Planning statement
In support of planning permission for
Yew Tree barn, Brakefield Road, Southfleet, Kent, DA13 9PY

New application

A new planning application is now being submitted for an alternative proposal. The main differences between this new application and refused appealed application is a chimney is to be provided and the rear dormer has been reduced in size and design modified.

Front elevation

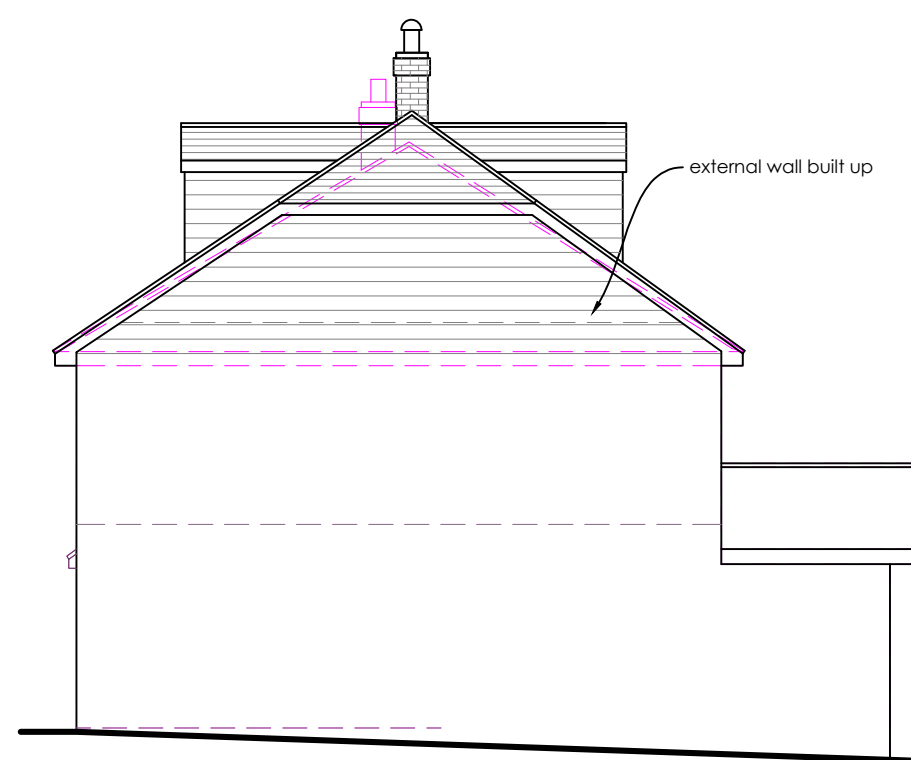
16. Chimneys are a characteristic feature which are present on many properties both within and outside the CA. Accordingly, the removal of the chimney from the appeal property would be harmful to the character and appearance of the area.

18. The front dormer windows would be significantly smaller and less prominent than the rear dormer. They would be well proportioned, with characteristic pitched roofs, and would not cause harm to the setting of the LB or CA.

A new chimney will be provided with a simple brick form to match the chimneys in the locality.

The front dormer windows are supported by the inspectorate and have therefore been retained.

Rear elevation

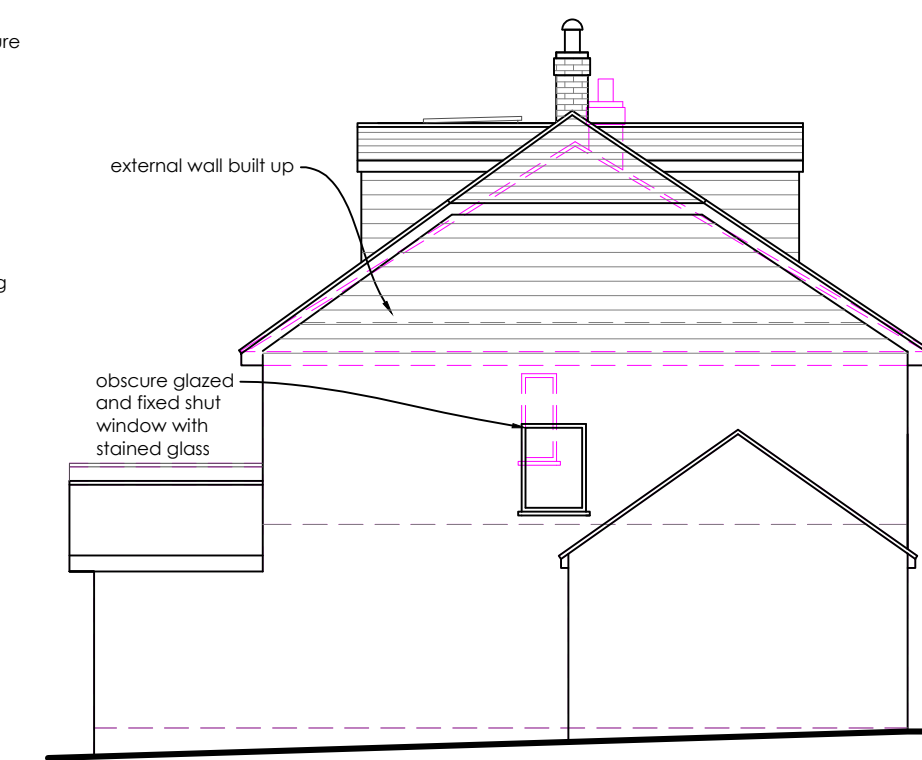
12. When viewed from Red Street, the appeal property, and particularly its rear roof form, are visible immediately to the rear of the LB. The rear dormer would be expansive, spanning much of the width of the rear roof plane. It would create a bulky addition which would take up a significant proportion of the roof slope. As a result, the rear dormer would be an out of proportion and dominant form of development.

13. The dormer's roof form would feature 'barn end hips'. Whilst there are examples of other properties with similar roof forms in the area, these are generally found on the principal roof form, rather than dormer additions.

15. Whilst I appreciate that the surroundings to the appeal site have been altered over time, the siting and scale of the rear dormer, and its significant projection from the roof plane would result in a looming feature to the rear of the LB. This would be particularly apparent from public viewpoints on Red Street, and would cause harm to the setting of the LB.

The width of the dormer has been reduced from 7.96m to 4.64, a reduction in width of 3.32m so as to ensure it is not a bulky or dominant feature of the roof.

The barn end hips have been removed and the dormer re-designed. The dormer consists of small pitched roofs dormers which are linked by section of flat roof. The link structure is set back from the pitched roof dormers in order to retain the form of the pitched roof dormers. The link structure has a flat roof and is set down from the pitched roofs ensuring that the link is subservient and unobtrusive.

A small flat roof window is provided to the link structure so as to increase the natural light within the new bedroom. This roof window is set back from the front of the dormer by 950mm so as to ensure it is not a prominent feature. It will only project minimally (150mm upstands to comply with building regulations) from the plane of the flat roof.

The dormer has been reduced in depth significantly (by 1500mm) so as to reduce its projection from the roof plane.

The scale of the dormer has been reduced and its new design ensures it sits sympathetically within the roof. Its small in-keeping design will enhance the area.
